DEVELOPMENT REVIEW BOARD  
SUPPLEMENTAL SUBMITTAL

PROJECT NO. PR-2019-002277  
Application No. SI-2019-00246

SUBMITTAL DESCRIPTION: DRB Site Plan Resubmittal.

**RE: Adagio Apartments  
PR-2019-002277**

Drawing file: PR-2019-002277_Feb_9_2022_Supp / C103-Conceptual Utility Plan Revised.pdf

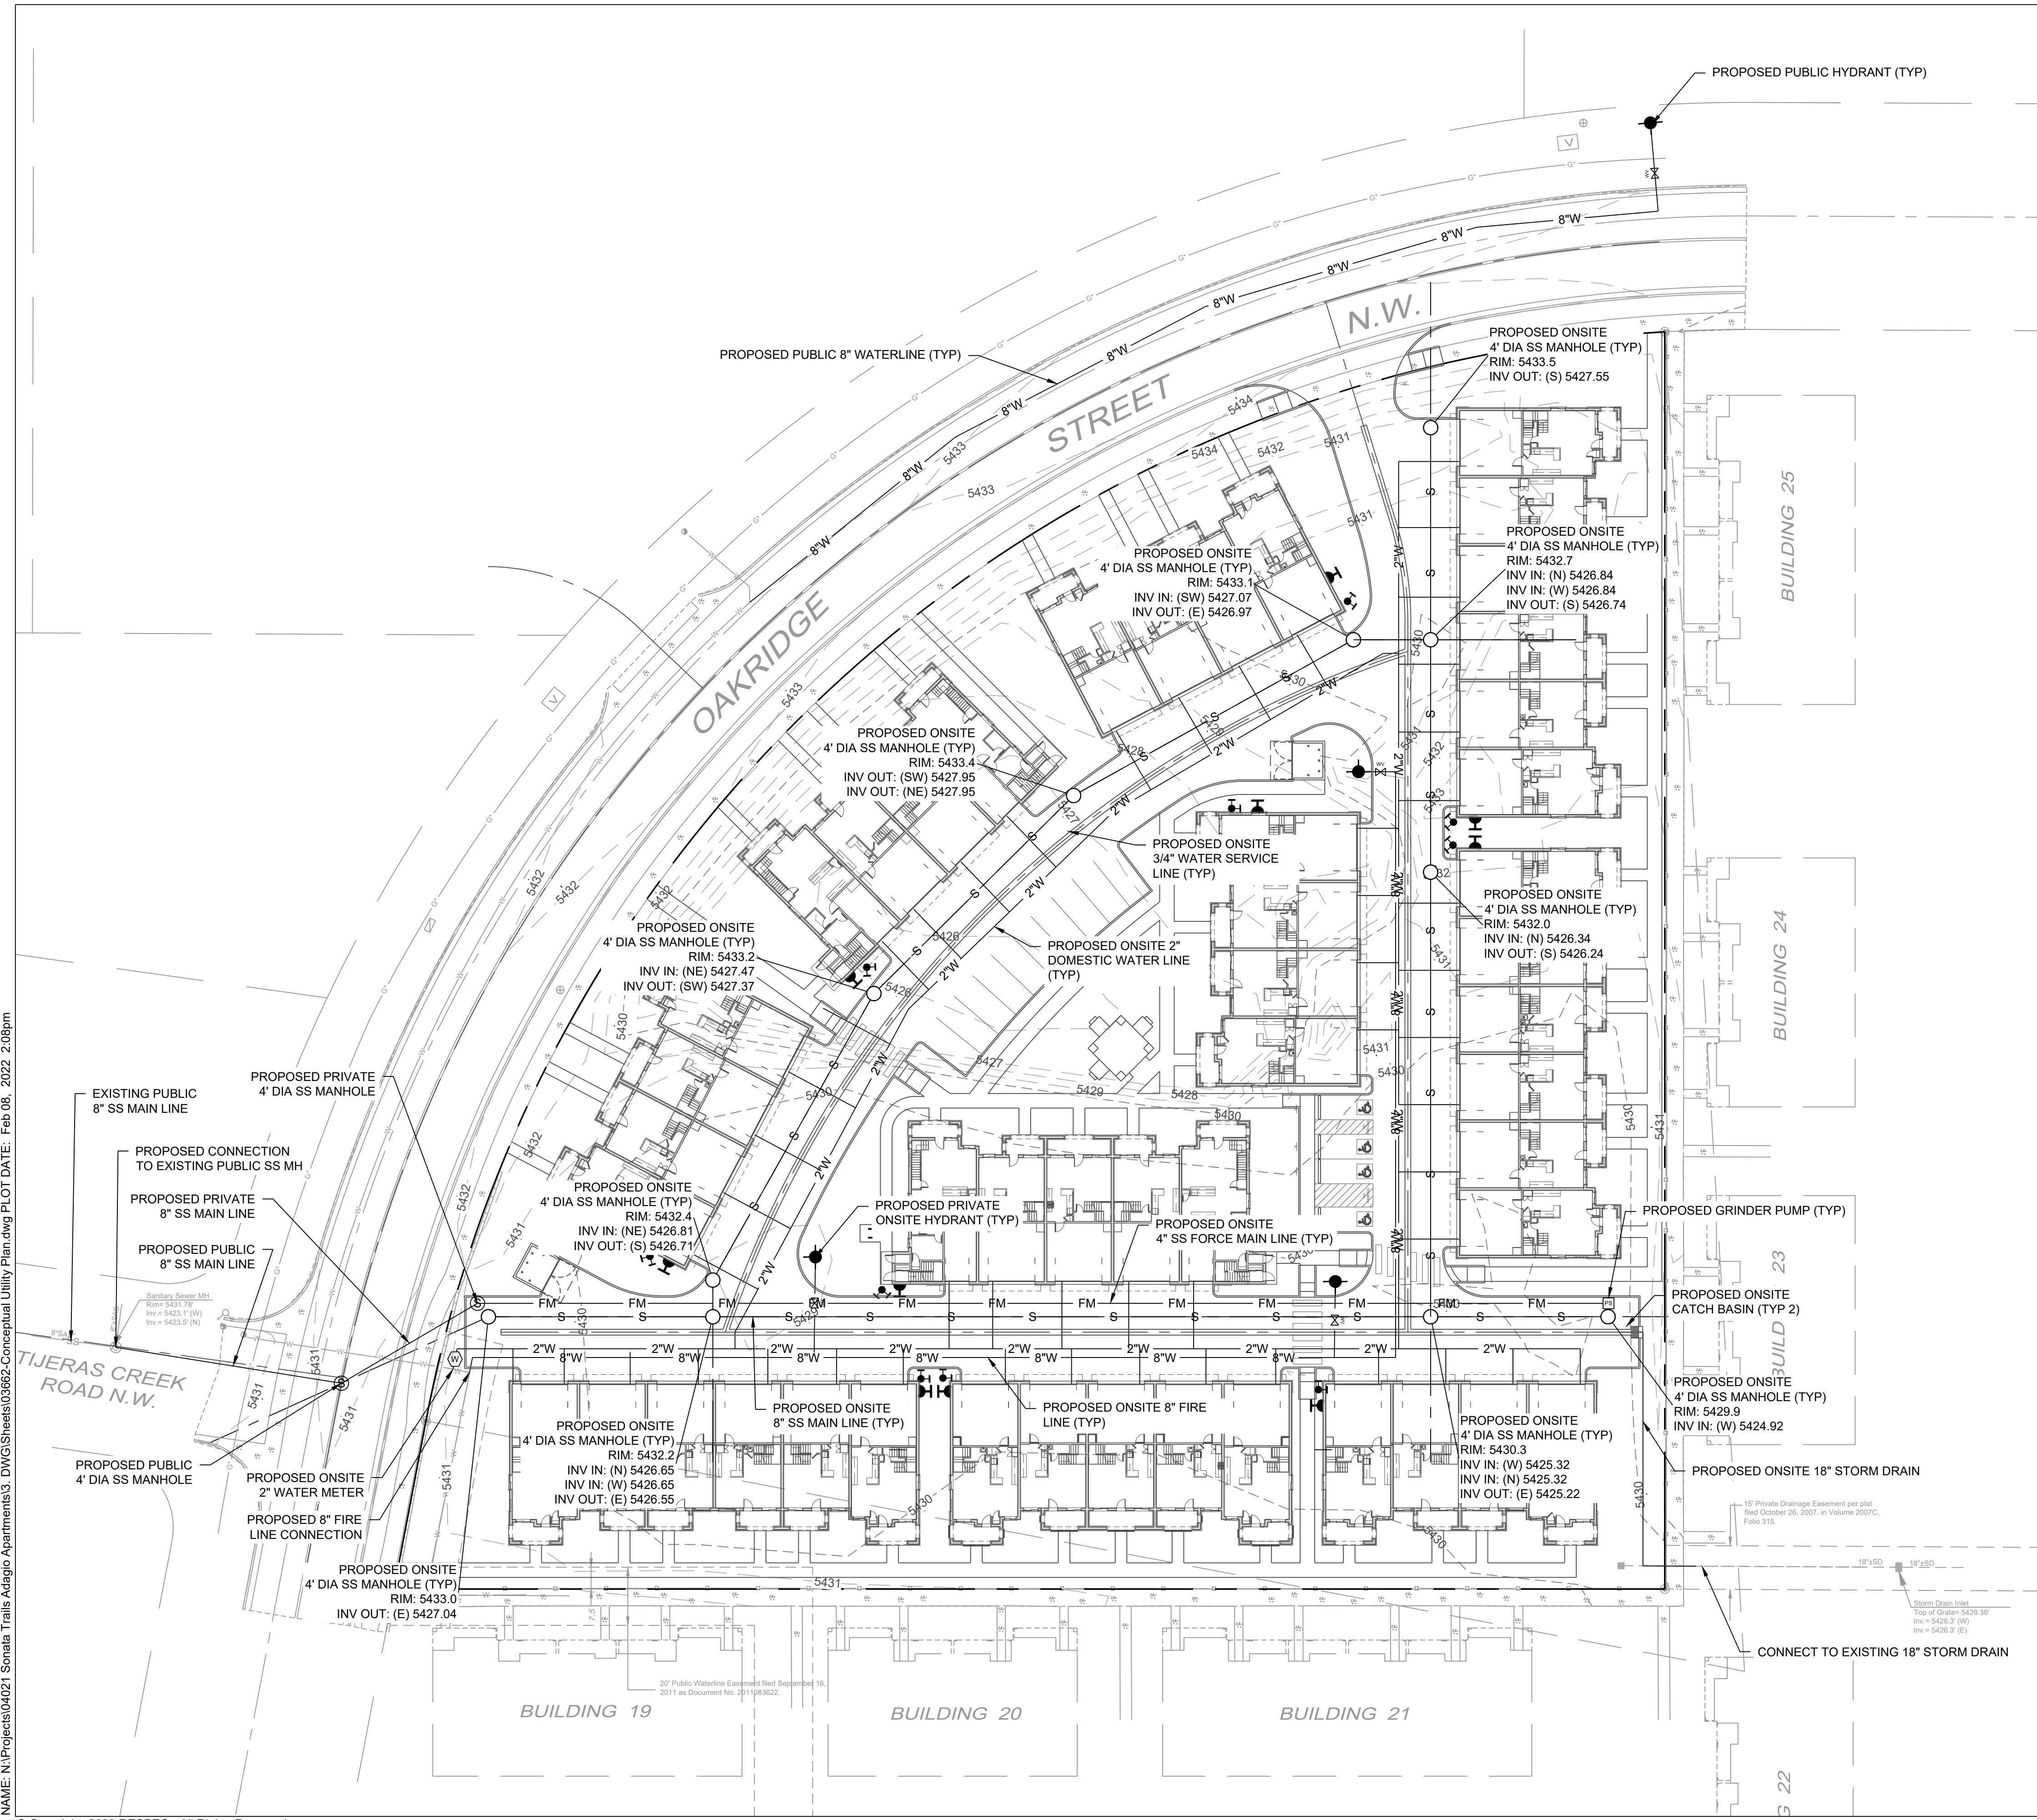
- / Serviceability letter #190401 has been issued and provides the requirements for service. Public waterline and sanitary sewer extensions are required in this serviceability letter. An infrastructure list will be required.
  - *Response: Acknowledged.*

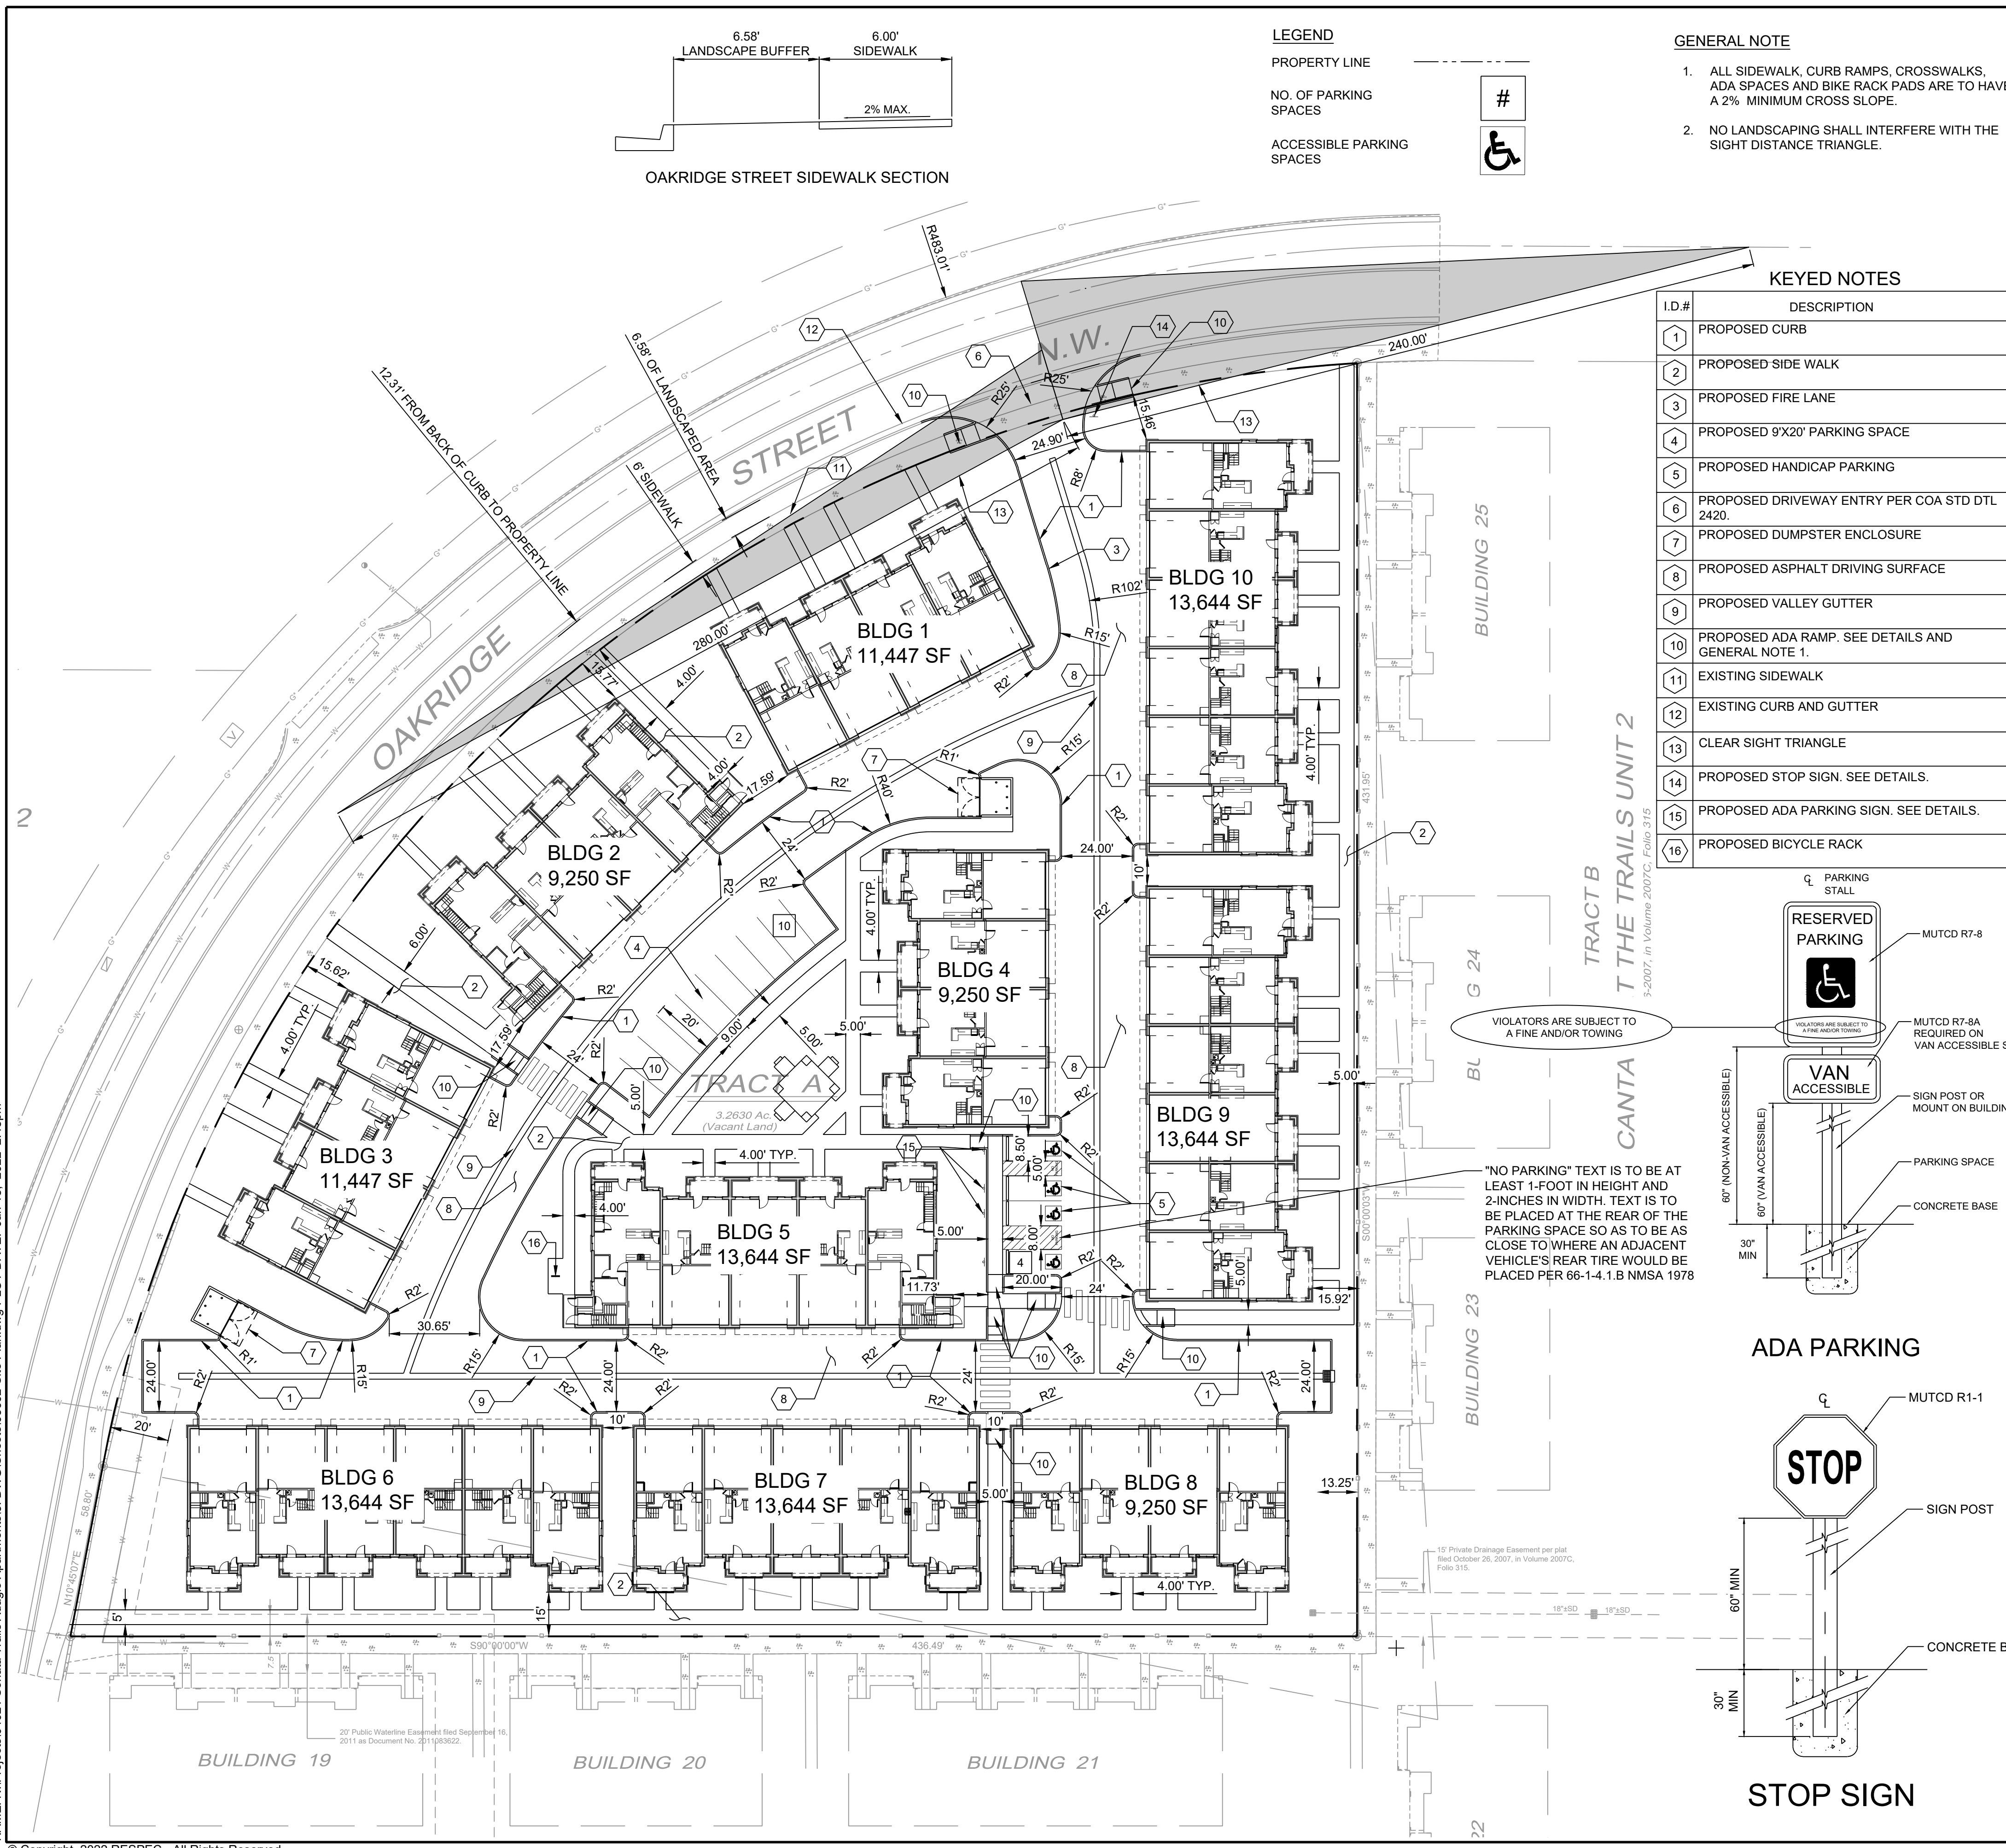
- / Have the number of bicycle racks match bicycle space requirements and dimension the bicycle rack space (Keyed Note 16).
  - o *Response: The number of bicycle racks and dimension has been added to the revised site plan sheet attached.*
